Subject: S6/2011/2817/FP – 1 The Cottages, Shepherds Way, Brookmans Park
Erection of two storey side extension, alterations to windows and door on rear elevation and insertion of velux windows.

I have reviewed the proposal for the above site and refer to drawing number 5856-01.

SITE PLAN  
SCALE 1:200 @ A1

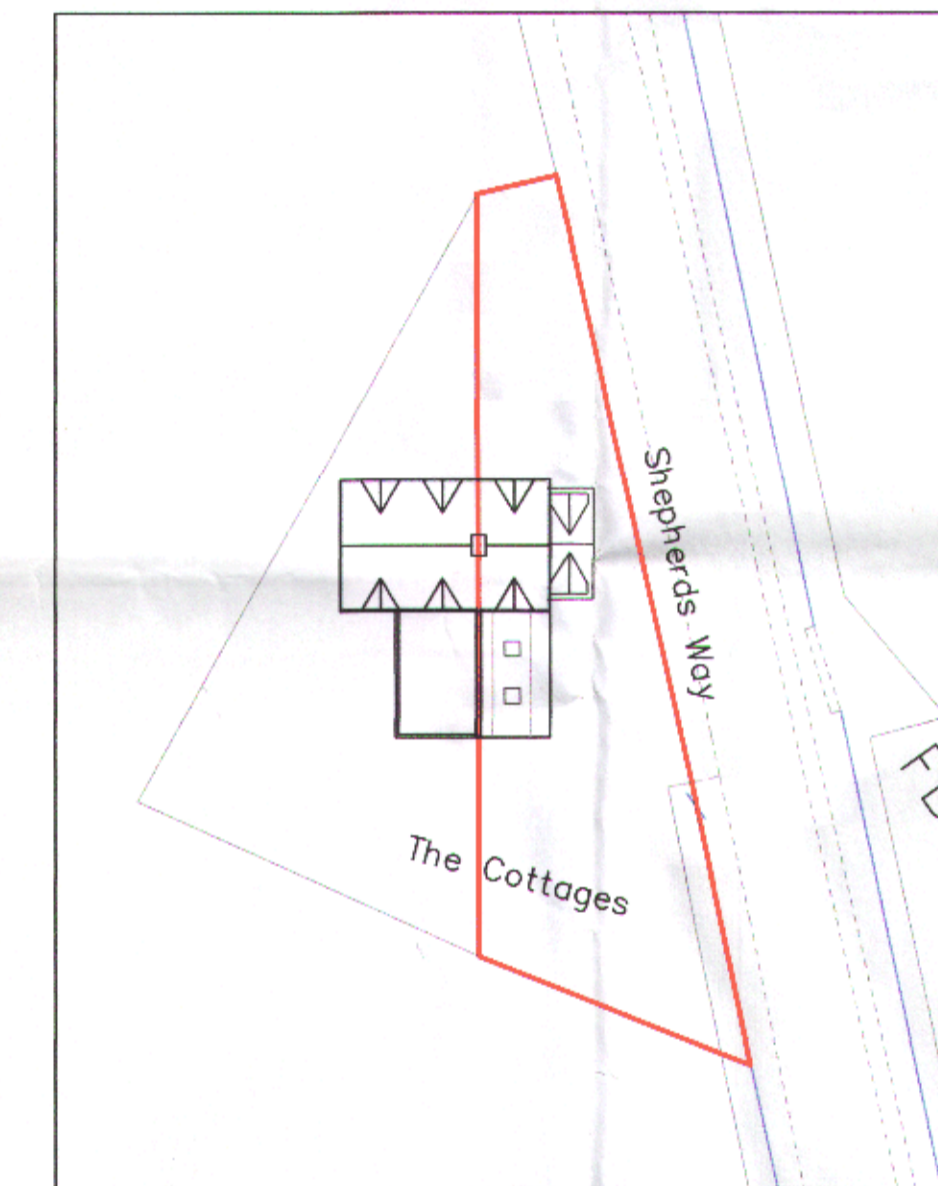
Arboriculturally: There is a very large ash tree within the rear garden of the above property. The working zone and construction zone will be outside the root protection area.
